M60/M62/M66 Simister Island – TR010064

Section 51 advice regarding draft application documents submitted by National Highways

The advice recorded in the table below relates solely to matters raised upon the Planning Inspectorate's review of the draft application documents listed above. The advice is limited by the maturity of the documentation provided by the Applicant and the time available for consideration and is raised without prejudice to the acceptance decision or the final decision about whether development consent should be granted.

FIGURE 2.4

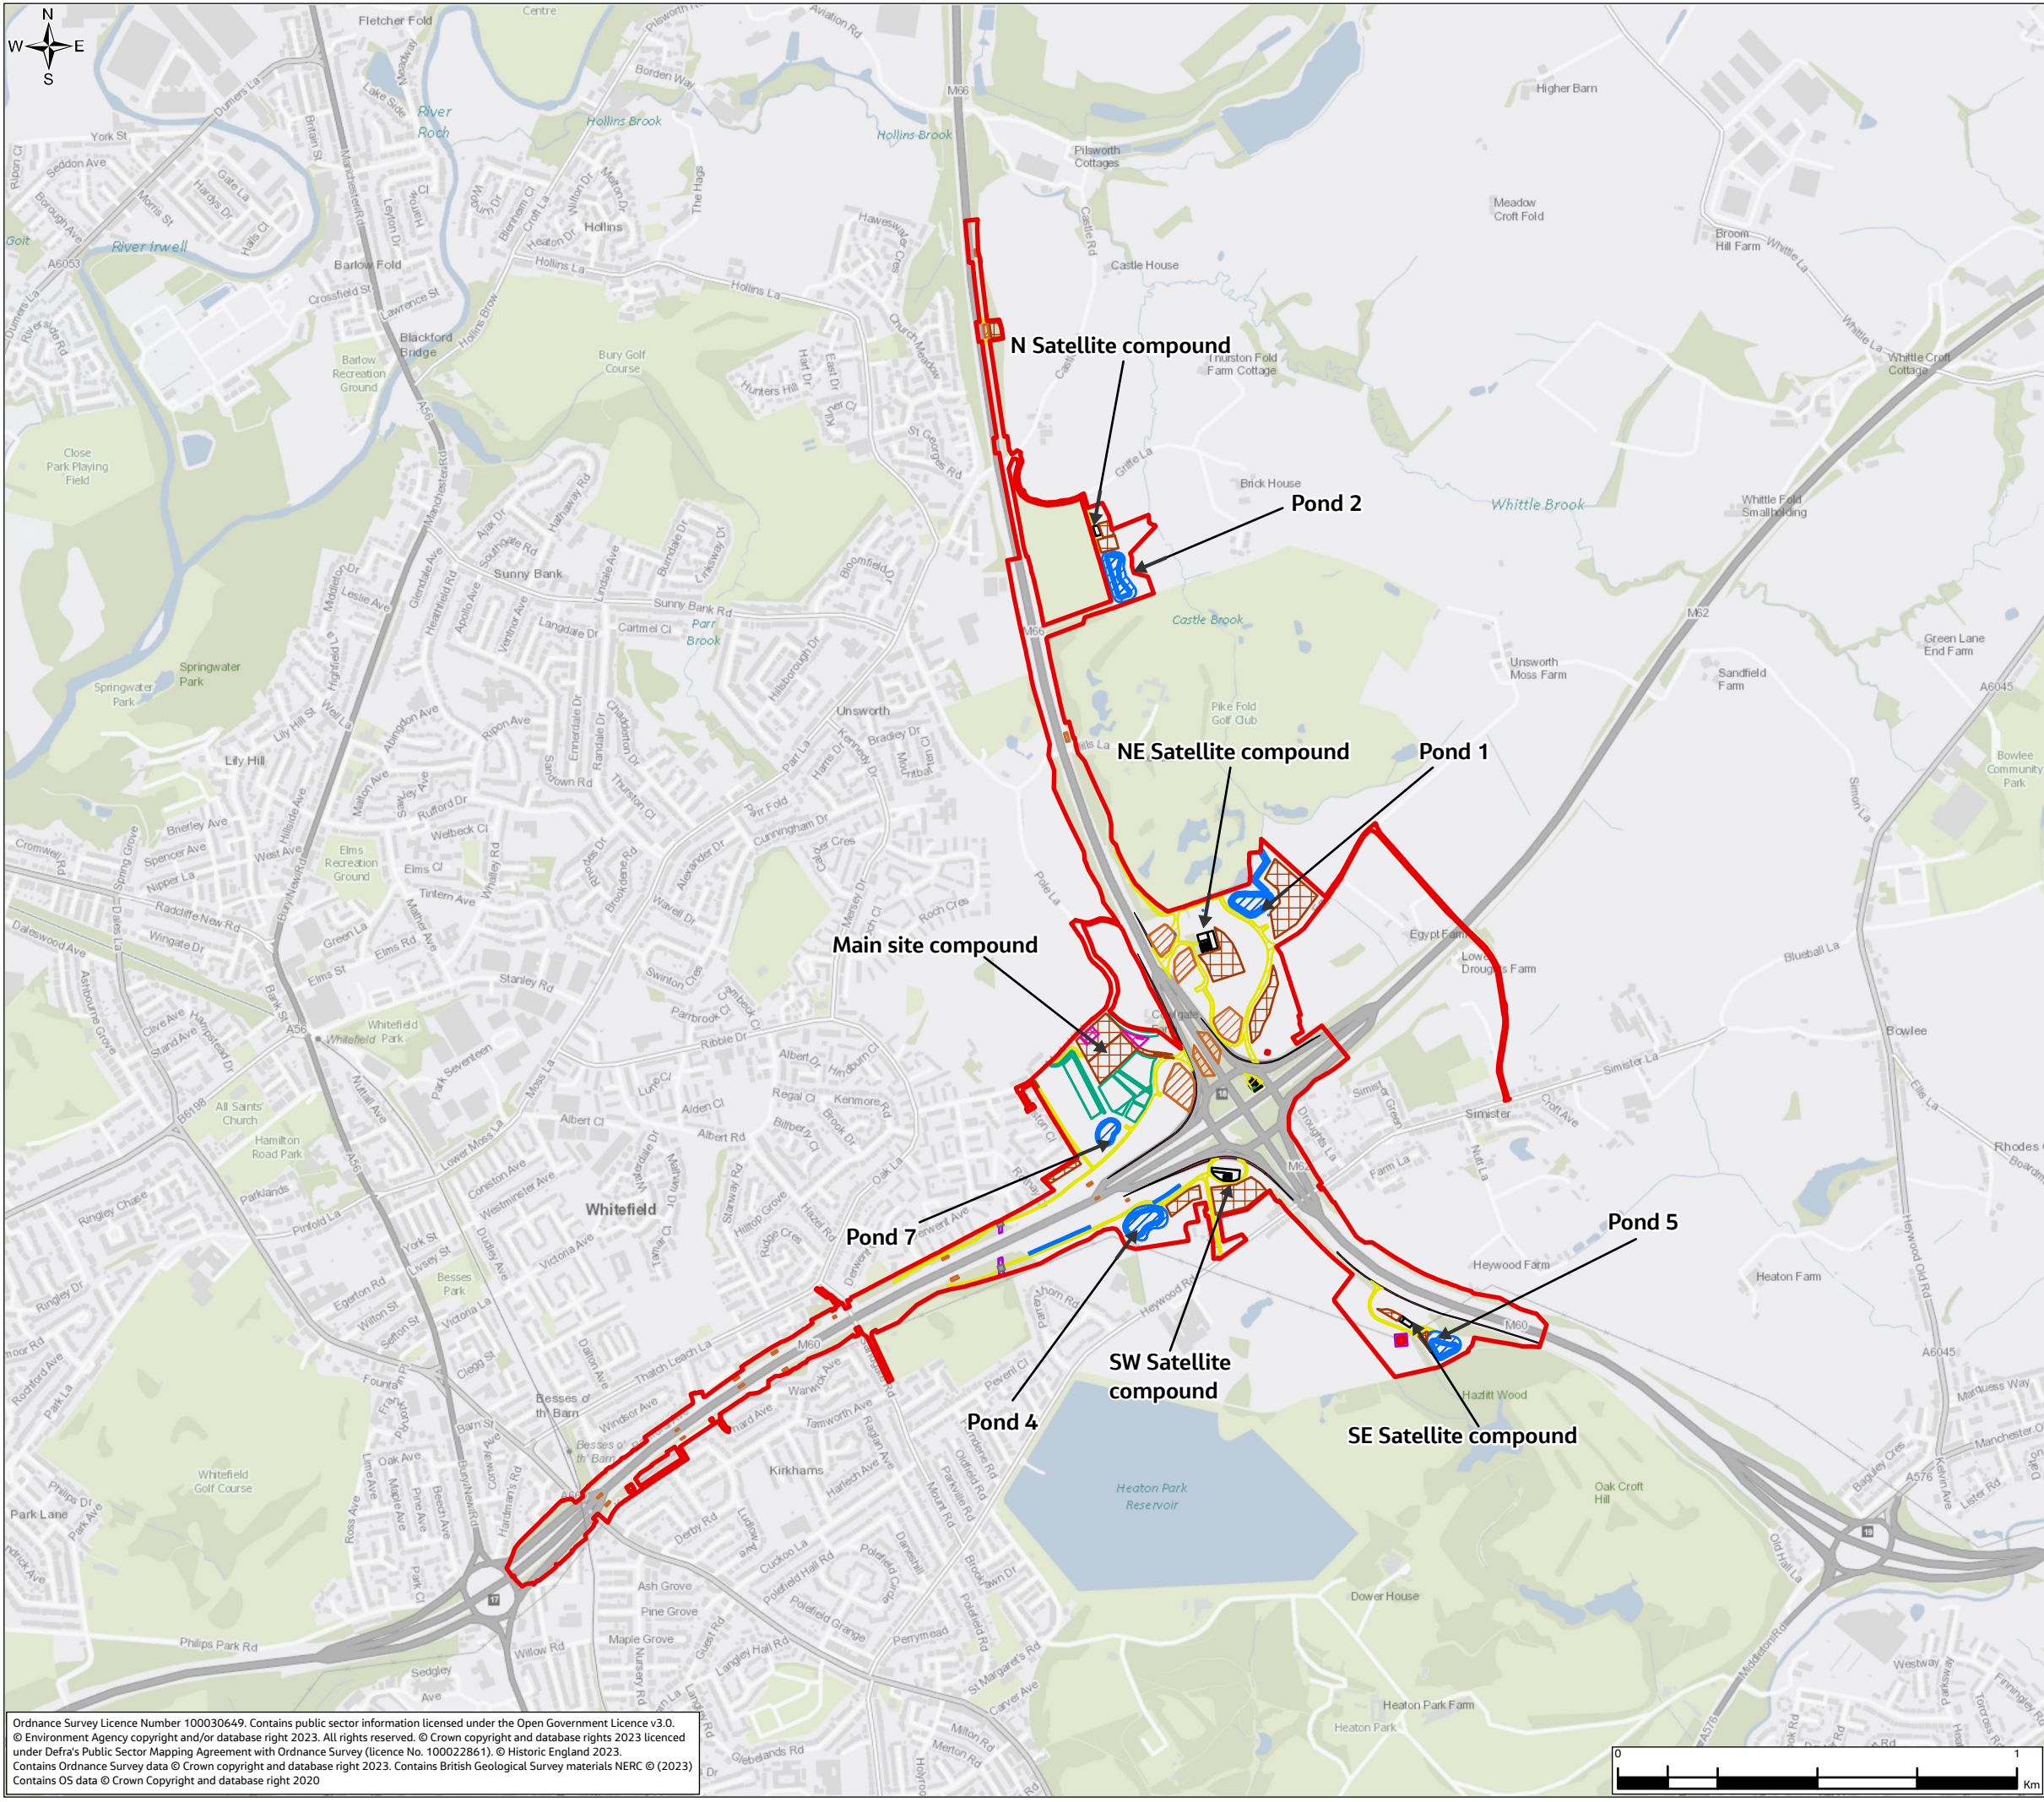
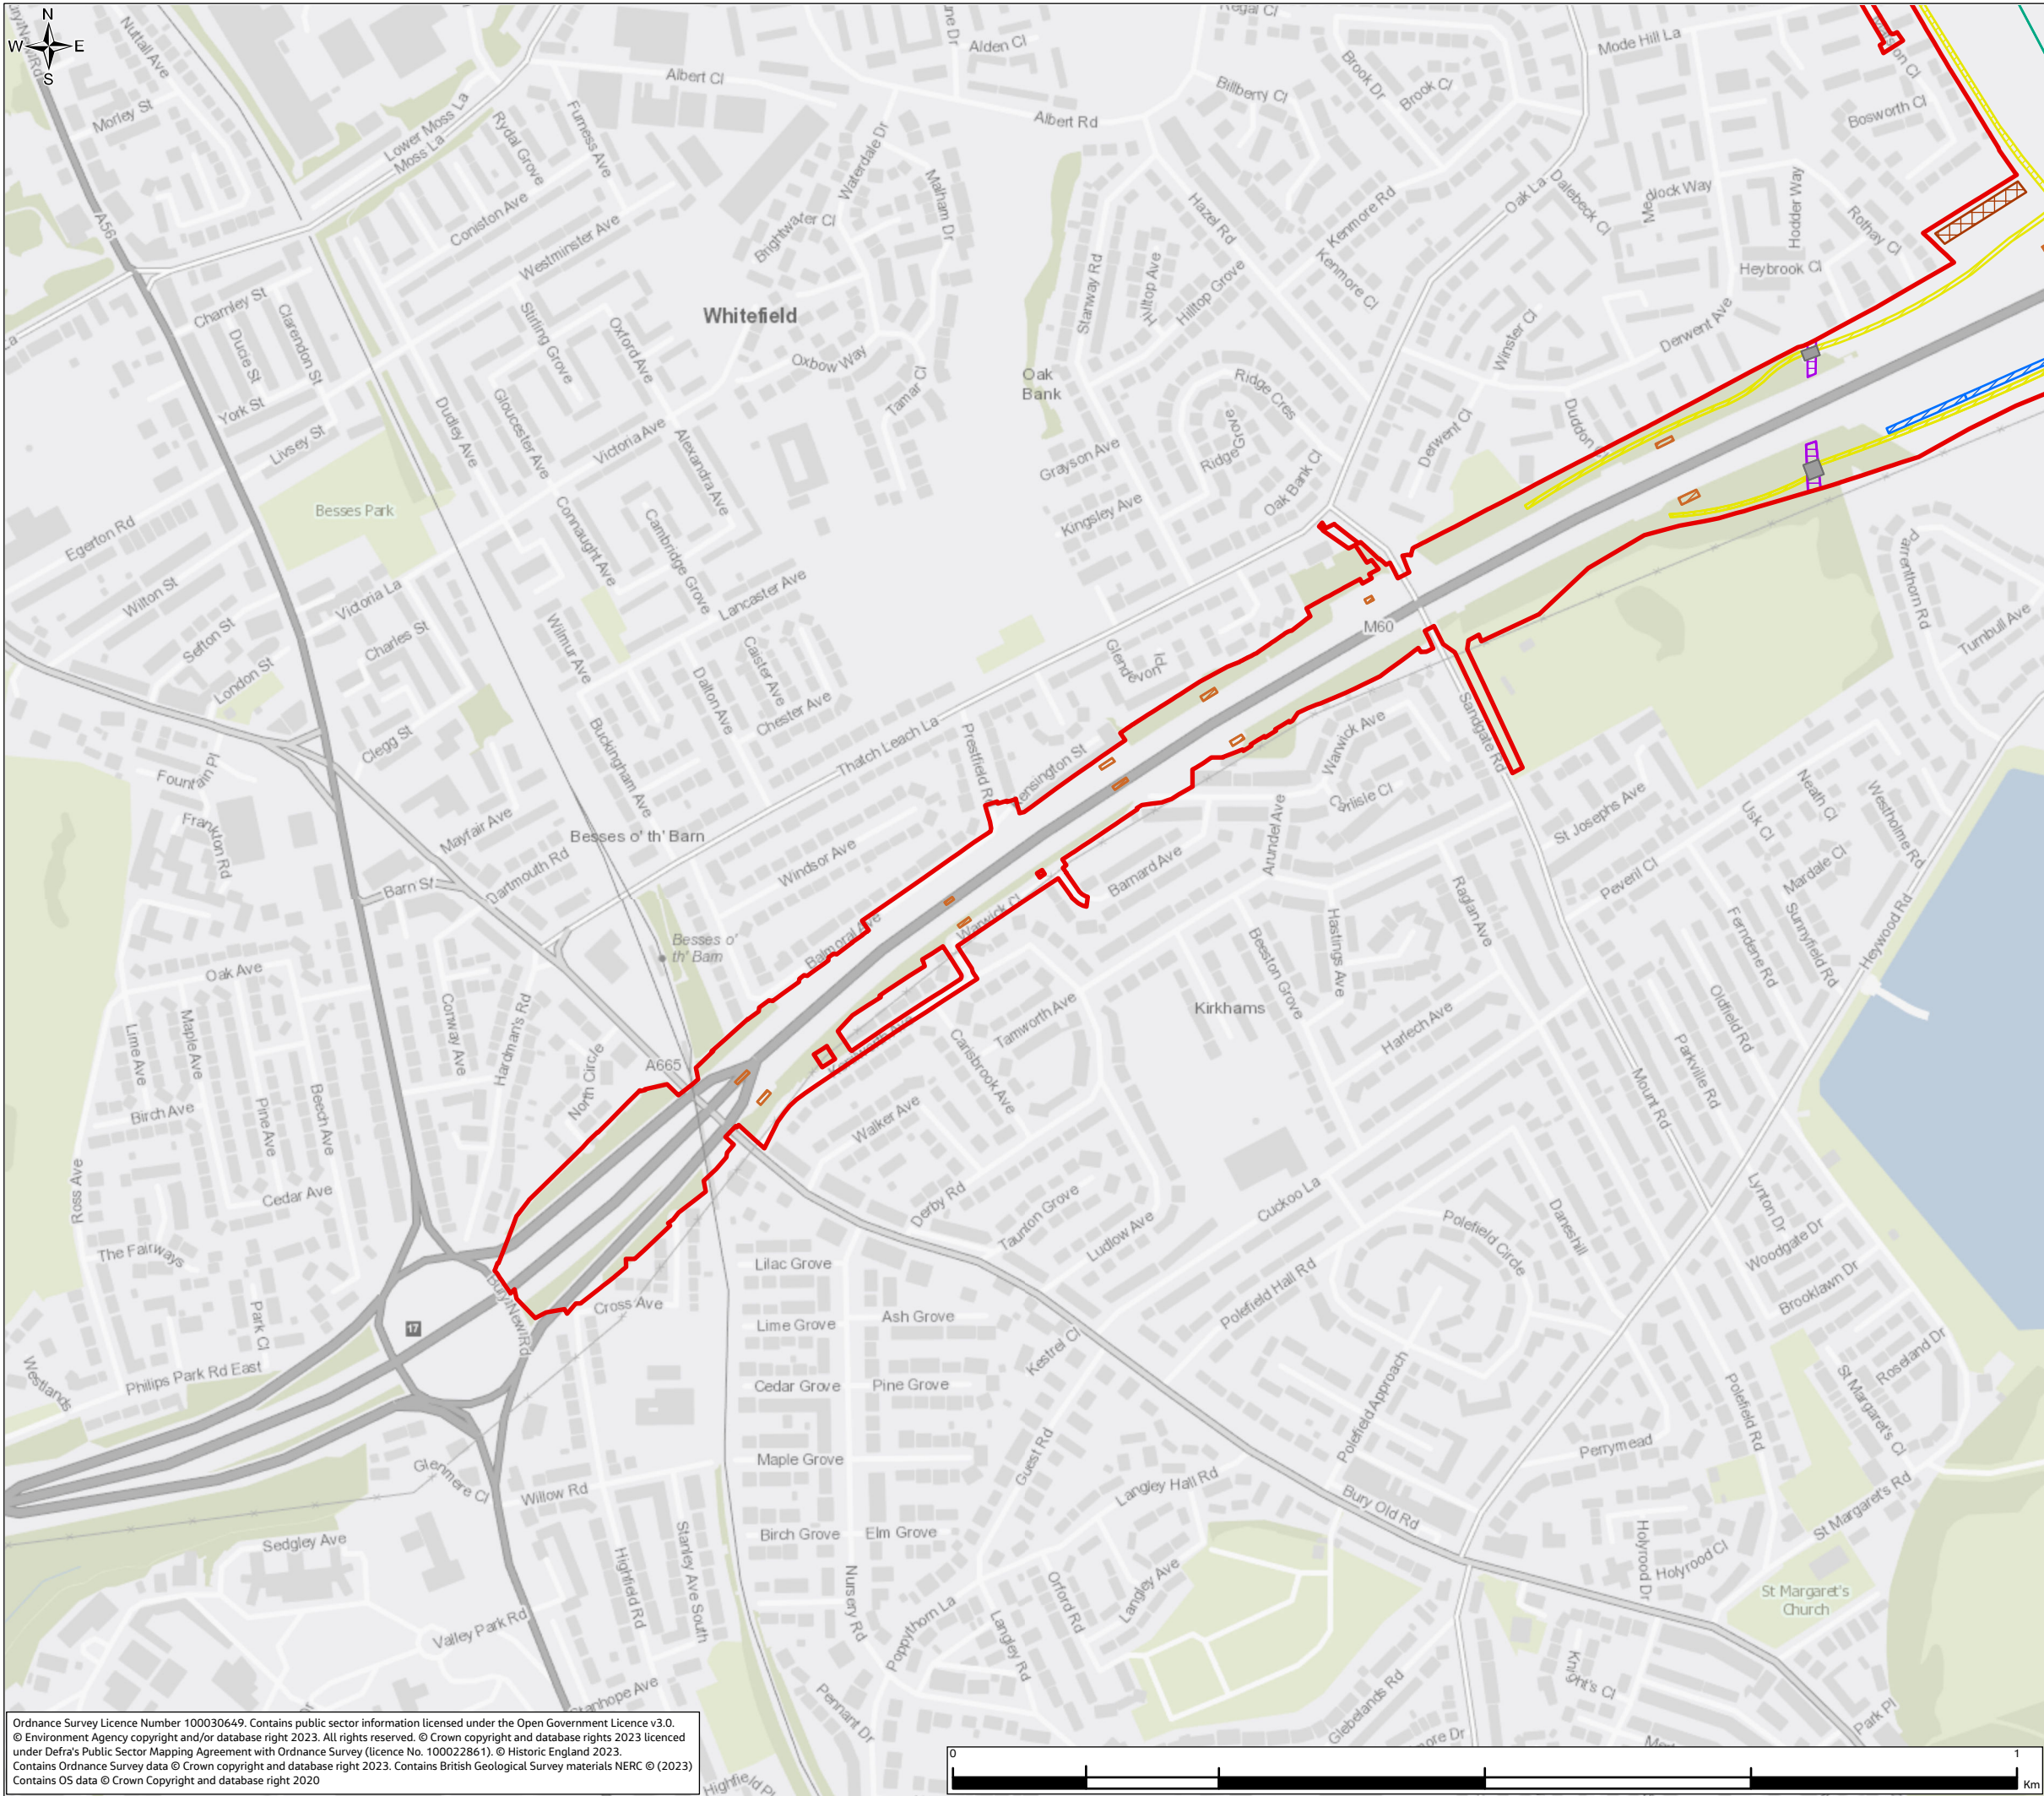
21.	2.5.82 and ES Figure 2.4	ES Figure 2.4 depicts several stockpile areas. These have not been described within ES Chapter 2. The Applicant should ensure that all elements of the Proposed Development are captured within ES Chapter 2 and ensure consistency between documents.
